City of Portland, Maine – Building or Use Permit Application 389 Congress Street, 04101, Tel: (207) 874-8703, FAX: 874-8716

Location of Construction: 34 Deering Ave		Owner: Morse, Stephen/Tanguay, John	Phone: 758 16 76 Page 773 28 12 H	Permit No: 970986
Owner Address: Box 8 Long Meadow Dr Gorham, ME 04038		Lessee/Buyer's Name: Gorham, ME 04038	Phone: 772-5463	<div style="border: 2px solid black; padding: 5px; text-align: center;"> PERMIT ISSUED Permit Issued: SEP 15 1997 CITY OF PORTLAND </div>
Contractor Name:		Address:		
Past Use: 4-fam	Proposed Use: Same	COST OF WORK: \$ 630.00	PERMIT FEE: \$ 25.00	Zone: CEB CBL: 053-C-027 Zoning Approval: 11/1/97 Special Zone or Reviews: <input type="checkbox"/> Shoreland <input type="checkbox"/> Wetland <input type="checkbox"/> Flood Zone <input type="checkbox"/> Subdivision <input type="checkbox"/> Site Plan maj <input type="checkbox"/> minor <input type="checkbox"/> mm <input type="checkbox"/>
Proposed Project Description: Extend Dormer 10'		FIRE DEPT. <input checked="" type="checkbox"/> Approved <input type="checkbox"/> Denied Signature: <i>[Signature]</i>	INSPECTION: Use Group: Type: Signature: <i>[Signature]</i>

REASON FOR PERMIT: exten

We wish to extend existing dormer #1,  
10' adding part #2, making total dormer 16'

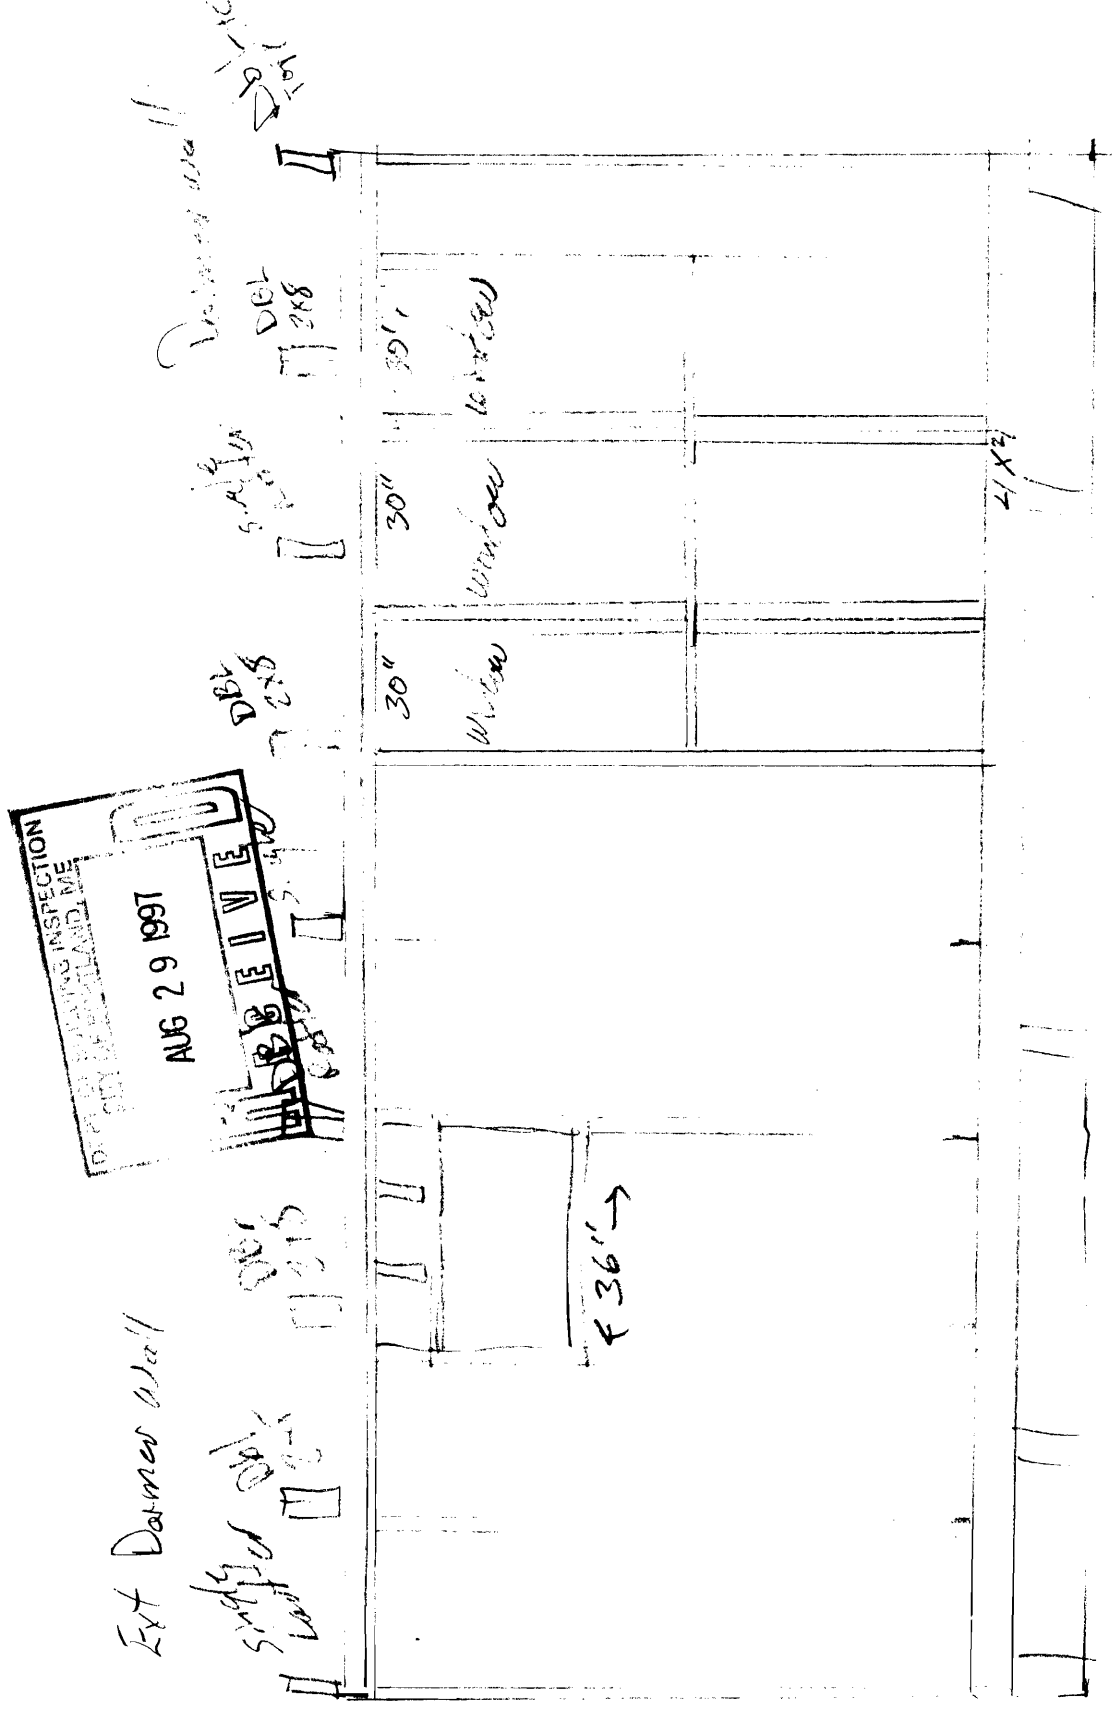
Note 2x8 rafters do not line up w/ 2x6 wall studs
 No Header over both window systems
 Roof is less than 4/12 pitch
 Rafter 8' span 2x8 e'oe (some dabled)

*Insp 2-20-95
Framing not to plans.*

JOHN TANGWAY STEVE MORSE 34 DEERING AVE. PORTLAND, ME.		
SCALE: NA	APPROVED BY:	DRAWN BY: RJP
DATE: 2/25/98		REVISED:
DORMER ROOF FRAMING, BEARING WALLS AND LOAD ESTIMATE		
ROBERTS CONSTRUCTION 729-8224		DRAWING NUMBER #2

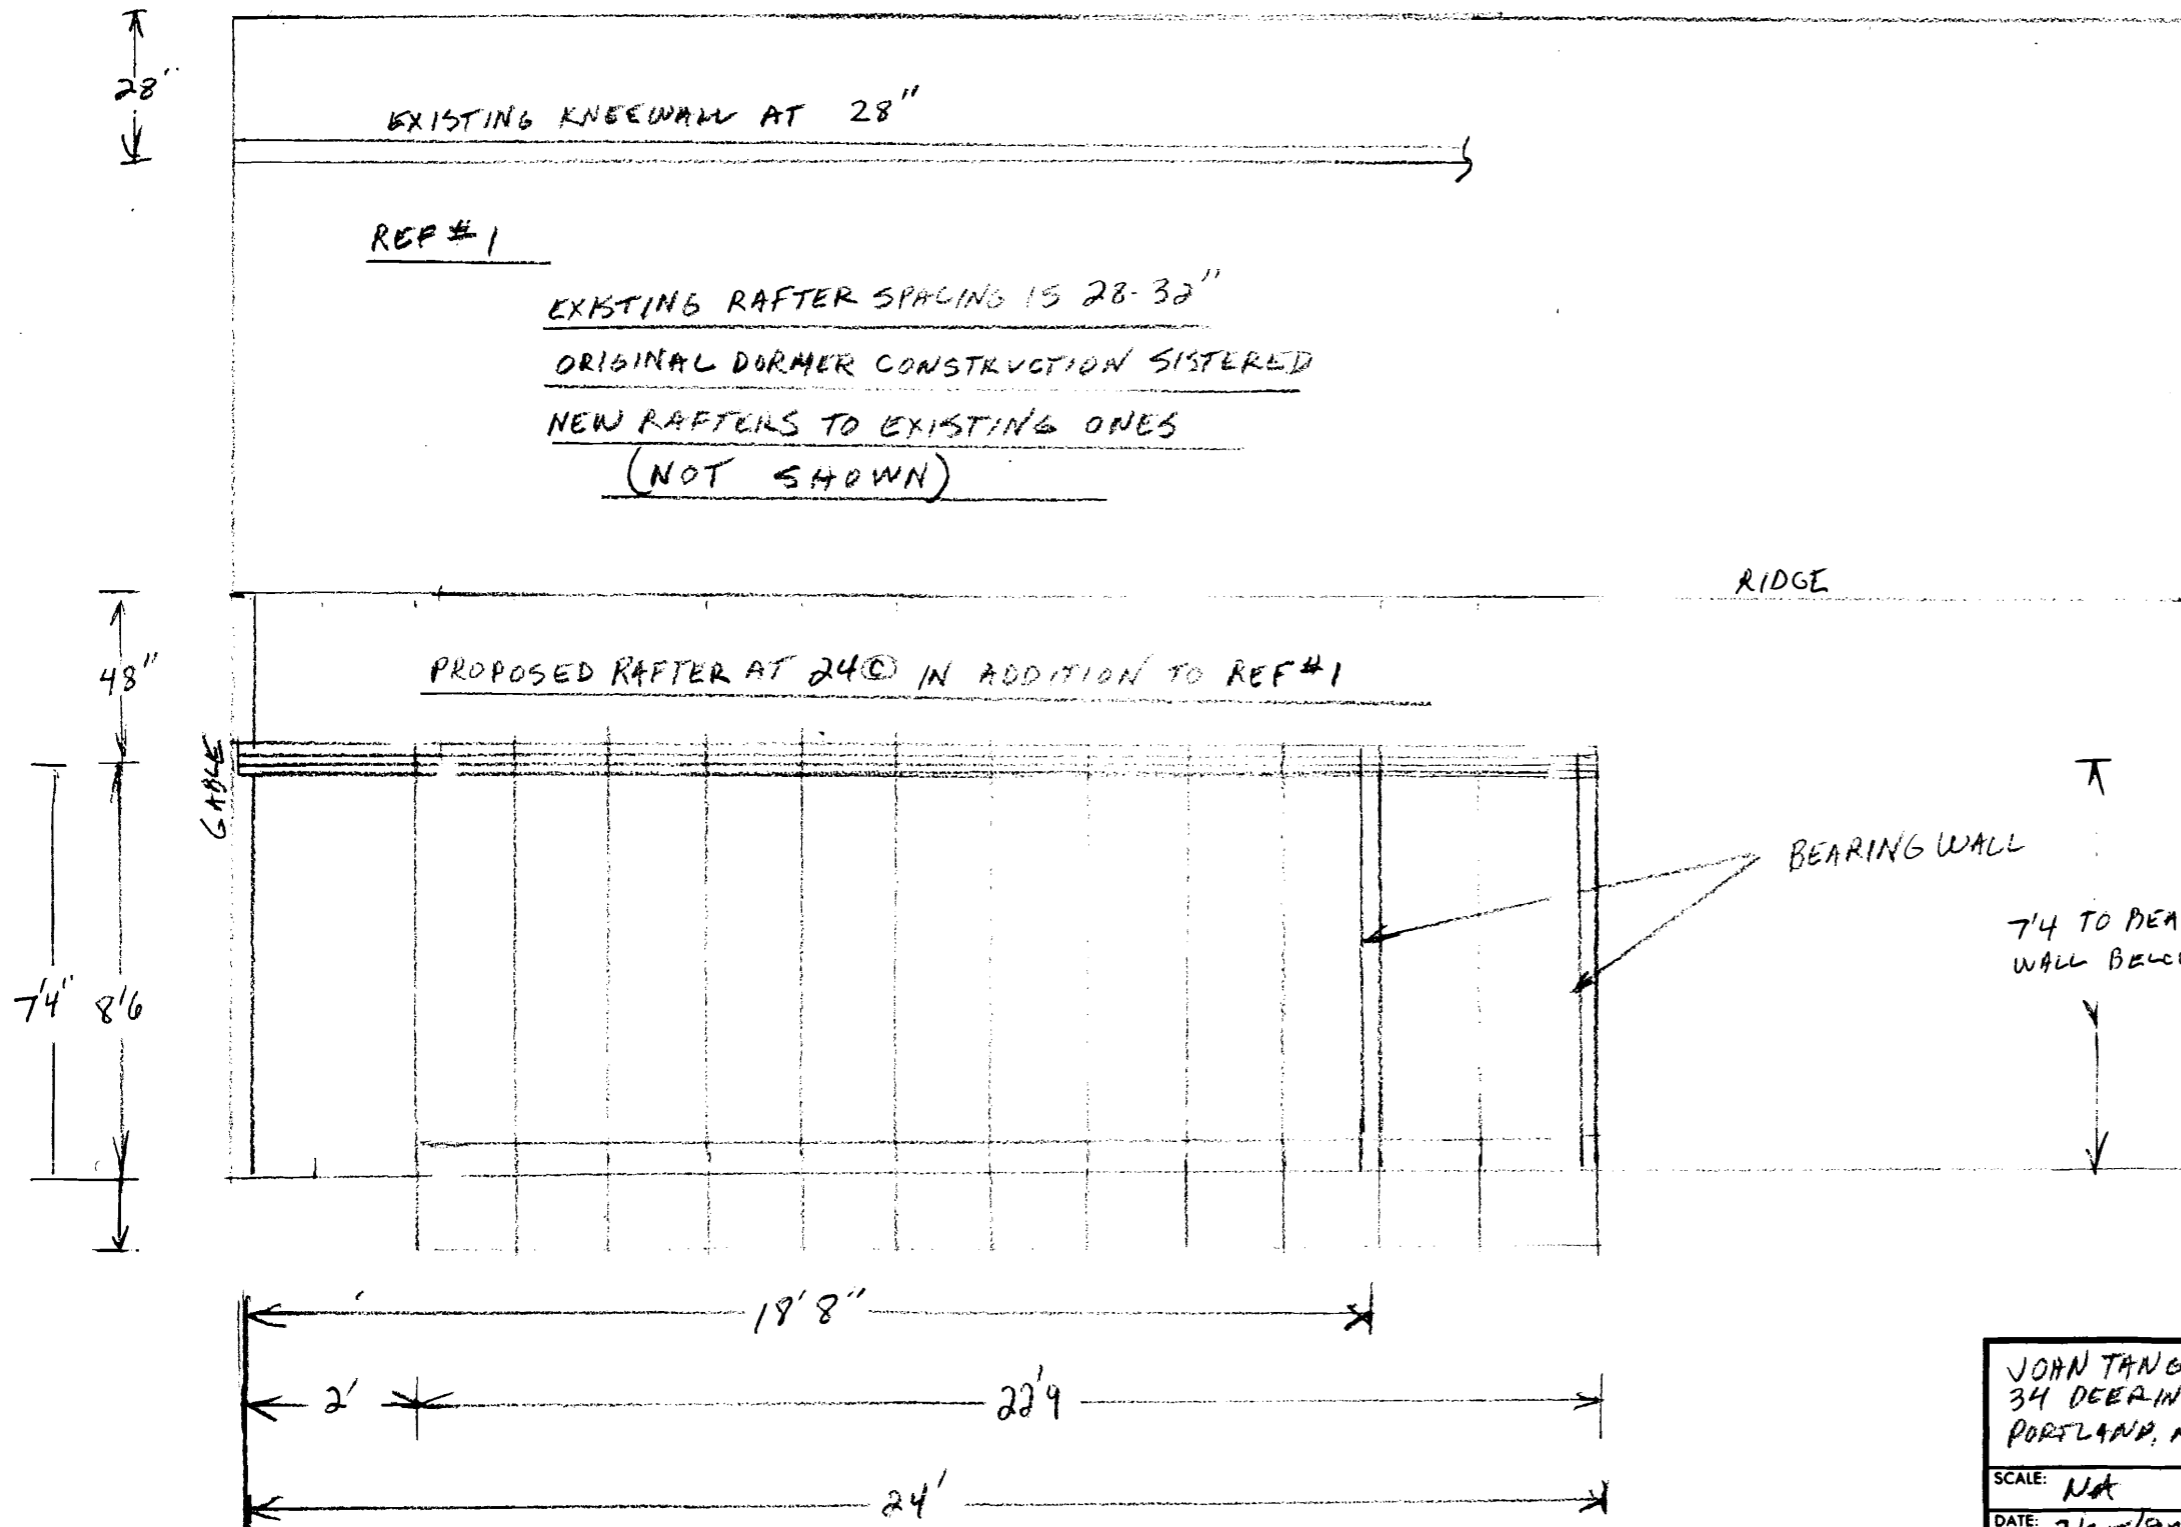
2-20-98 - wall on corner 2x6 (200), Rafter 2x8

11 Rafters 1 2 1 2 2 2 1 2 1 2 1 2 1 2 1 8'-0" 4/12 pitch /
8' Span / over windows 30" run then 2 studs @ ea. end + middle.
36" span over 2nd window / no Venter / Pb-peanuts
